From: Michael Mariner [REDACTED]
Sent: 07 January 2022 19:25
To: Simon Davis <Simon.Davis@arun.gov.uk>
Cc: Planning <Planning@arun.gov.uk>
Subject: P/165/21/PL Objection

We strongly object to this planning application.

Drawing Title	Site Layout
---------------	-------------

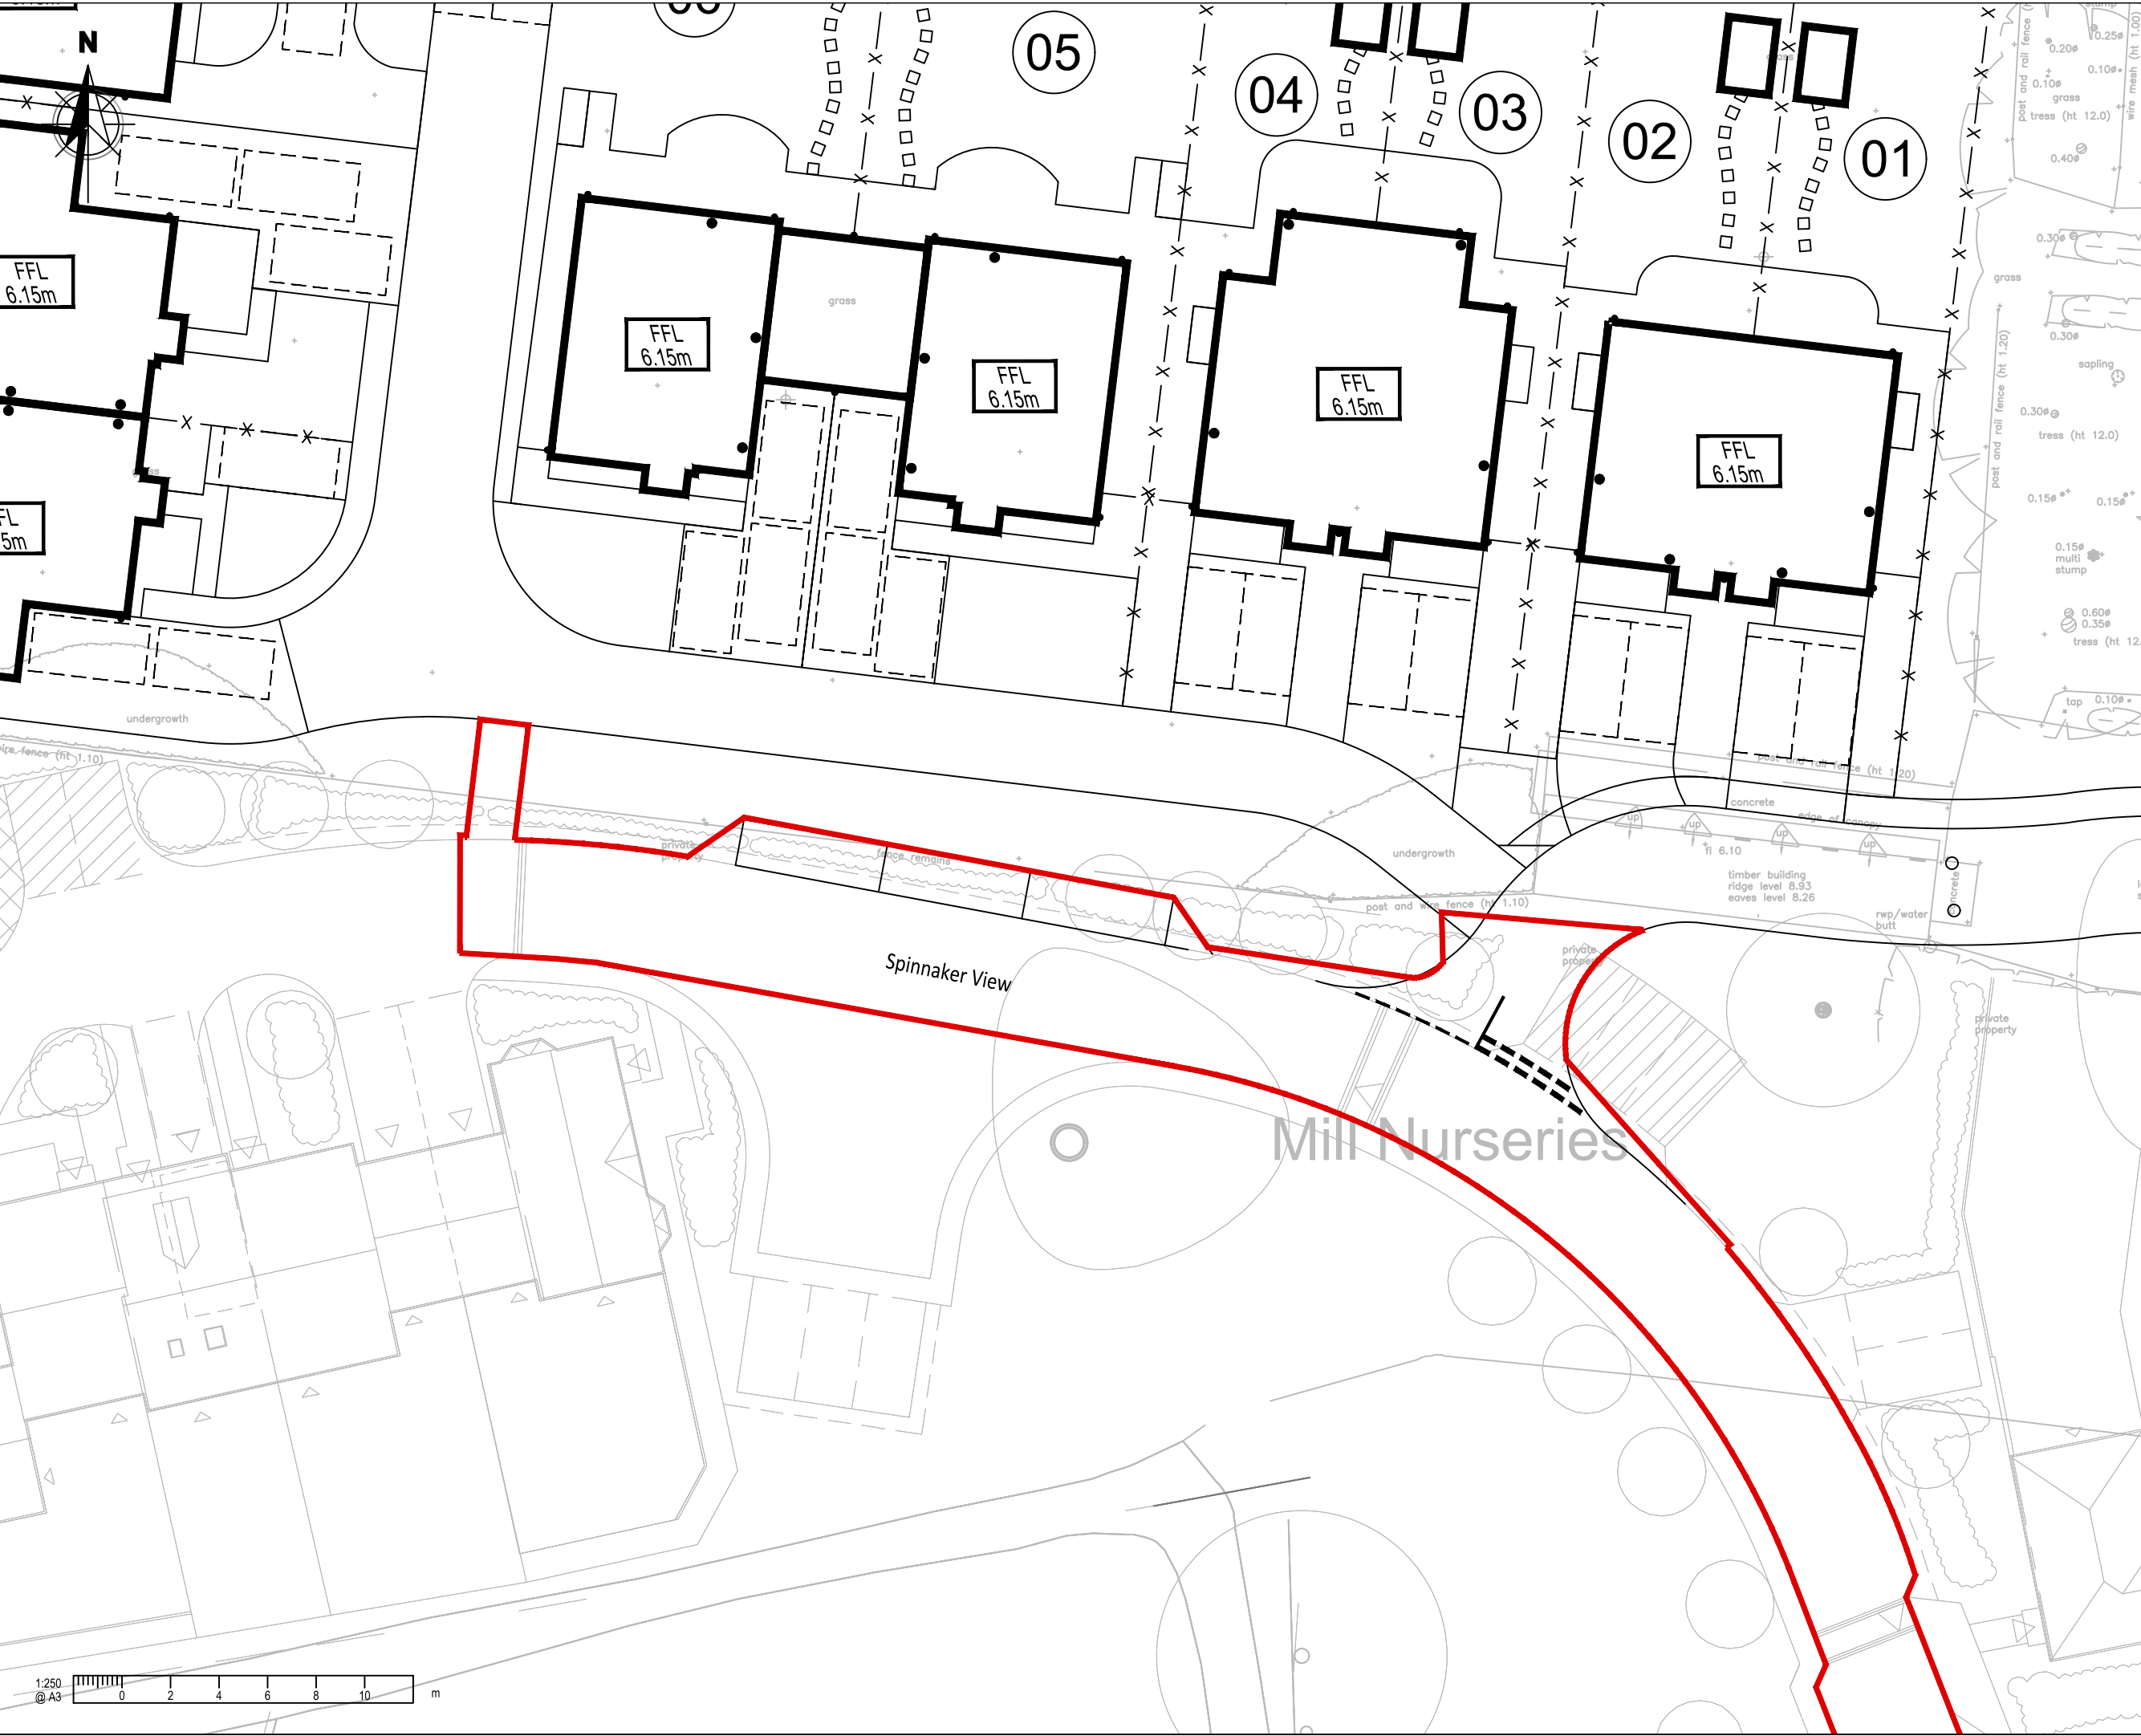
Pagham parish council back then strongly objected to the very first plans to do with the footpaths in Spinnaker view as they were initially insufficient and dangerous, however now this application has been submitted to access via Spinnaker View Pagham parish council don't seem to mind now and have approved in leaving us the residents in a dangerous situation by removing our footpaths and replacing with parking spaces?? CONTRADICTIVE SOMEWHAT

Also the developer wants to make a footpath through our private boundary fence to allow access for the refuse collections to their site by leaving the HGV 's on our delicate permeable paving for a longer period to collect the refuse from the site by walking the bins. We accept that we do get blocked in by the refuse lorries currently, but we will not accept this for their gains.

The same position the developer wants to remove our footpath and replace with parking spaces is actually in our no dig zone due to Poplar Populus T29 which has a root protection Zone which crosses over to the Inglenook development site.

Also the same no dig zone as well as running in front of our existing parking spaces is where we have our vital services, electricity, Telecoms and water.

On application the developer has stated that we have no Trees or hedges at the proposed access site. This is wholly wrong as we do have trees and hedges and other vegetation running along our boundary fence as well as a wildlife corridor. These are our trees and foliage that were approved on our planning for this site and we now pay to maintain and these will not be removed in any circumstances.

The boundary lines that the developer is using on this application looks like he has taken more of our private land in order for him to gain additional space as he does not have enough of his own.
